From:
Sent: 28 July 2026 23:06
To: DC Admin
Subject: Urgent representation – application 2026/92032, Land off Birkby Road

I wish to raise concerns regarding non-material amendment application 2026/92032, relating to the land off Birkby Road/Occupation Lane.

Drawing title
Garage Floor Plan and Elevations as Proposed

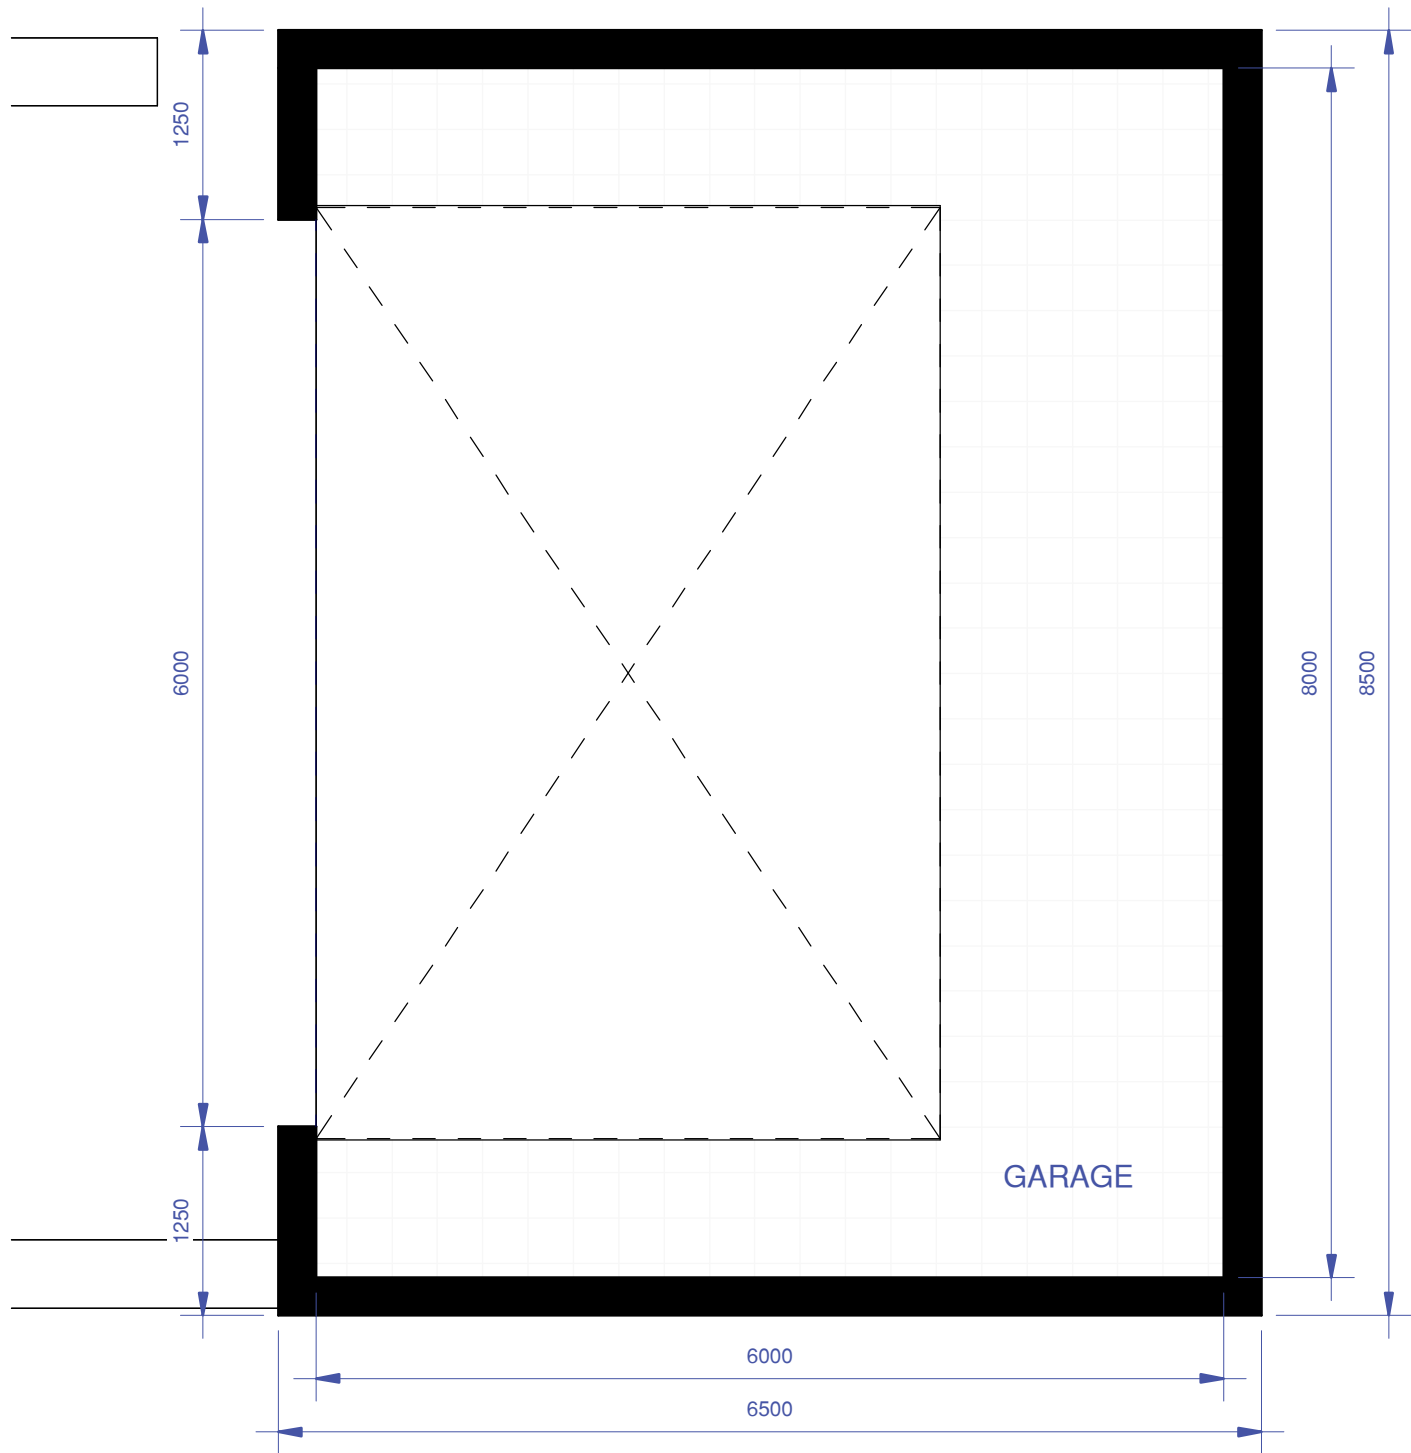
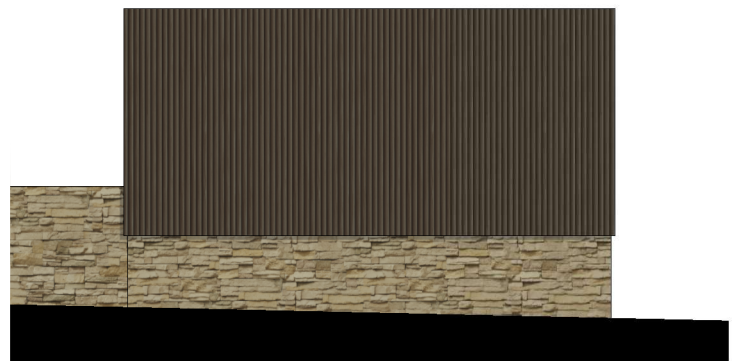
The amended drawing states that the house footprint has been altered following confirmation of the legal boundary and that the garage has been repositioned and resized. However, the submitted material does not appear to provide clear dimensions showing the movement between the approved and proposed positions.

Drawing no
Site Plan as Proposed

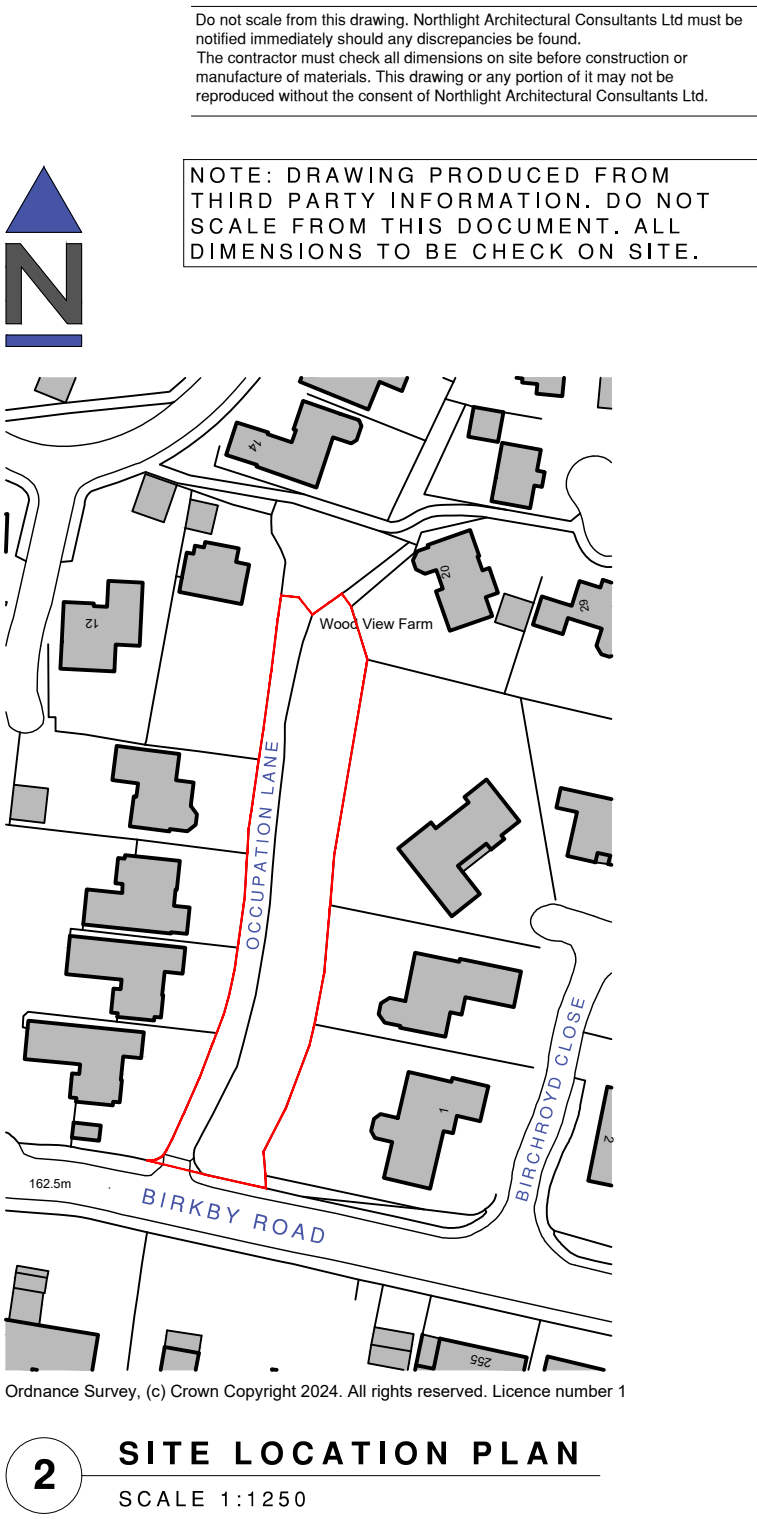
1. The precise distance and direction by which the house and garage have moved.
2. A dimensioned overlay comparing the approved and proposed layouts.
3. The revised distances from the house, garage, foundations and services to the access track and surviving dry-stone wall.
4. Whether the changes affect ground levels, drainage, access, neighbouring interests or any conditions attached to the original permission.
5. Whether construction has already commenced in accordance with the proposed amended layout rather than the currently approved plans.
